Re: 63 Midhurst Drive, Ferring, BN12 5BQ

Application no. FG/1/18/HH

Proposal: Loft conversion and rear extension.

DRW NO 4 SCALE 1/50 (A3)
PROPOSED ROOF PLAN

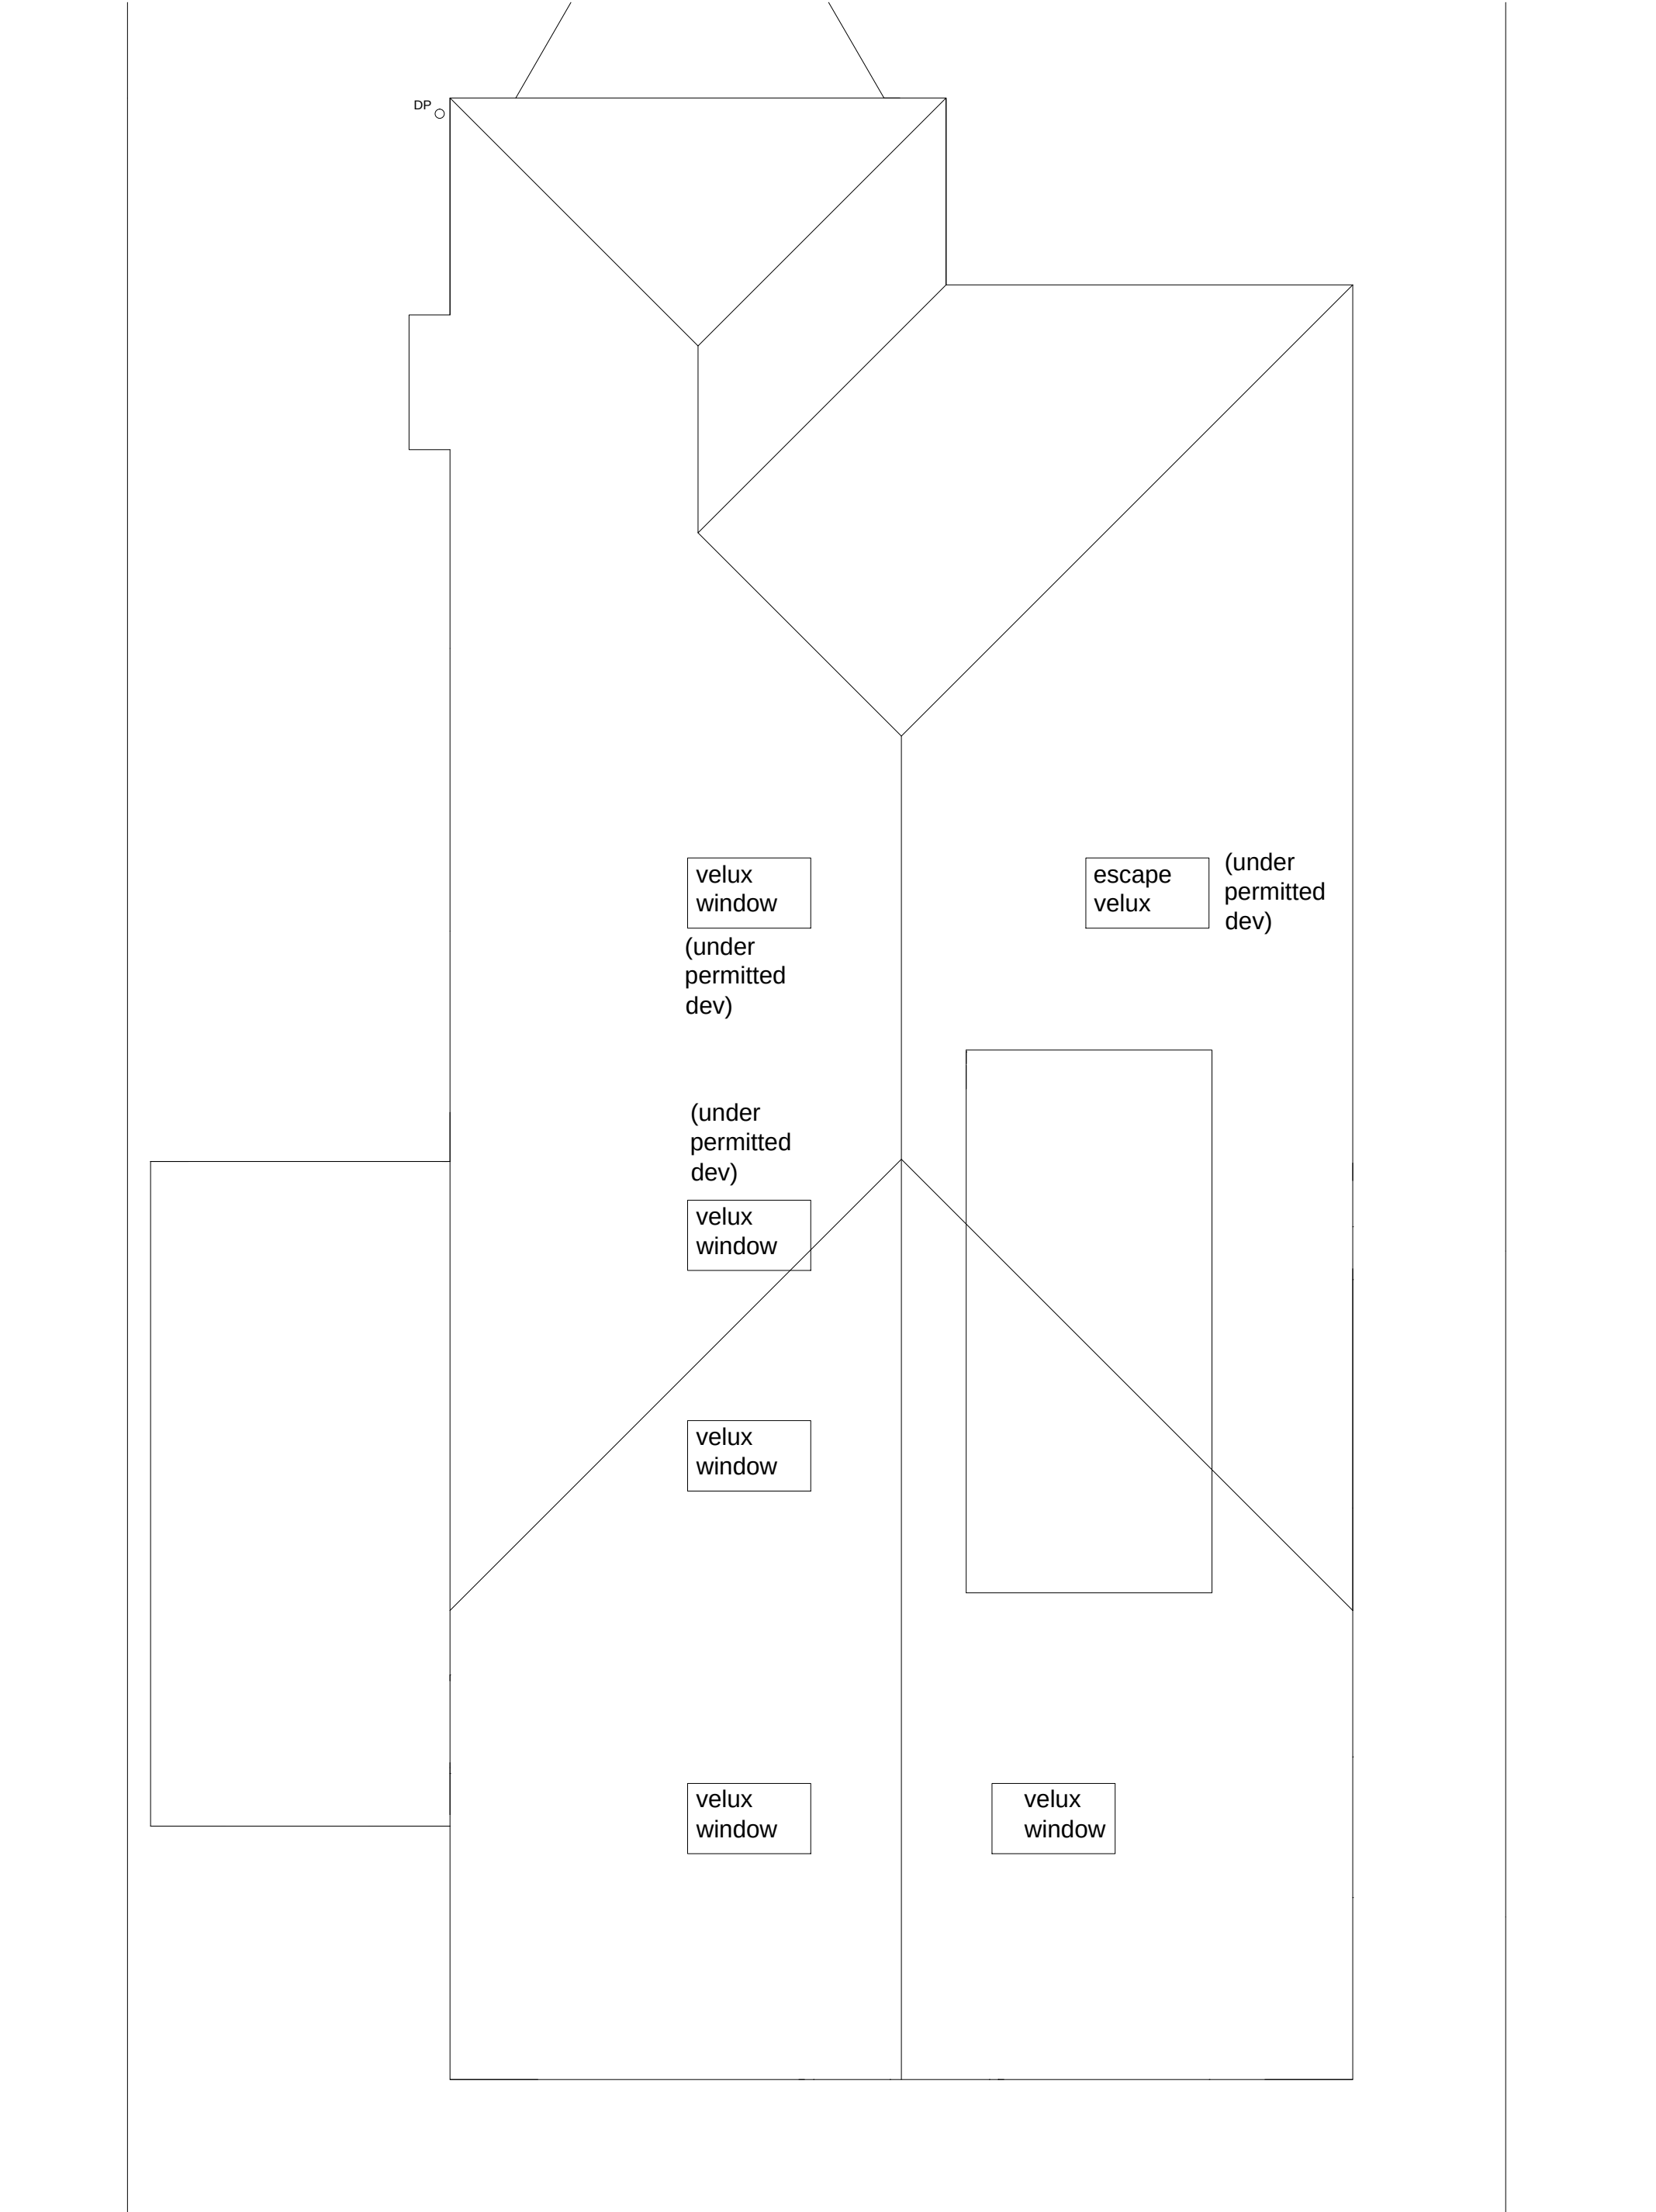
We believe that the proposed extension, with its gable end and "Juliet" balcony impinges on the Ilex Avenue by its bulk and height to the detriment of this local amenity and to the enjoyment of the users of the Avenue.

Although replacement of the gable end with a suitably hipped end and possible rooflight may alleviate the harm to the Avenue to some extent, we would strongly urge the Council to reject this application as currently proposed.
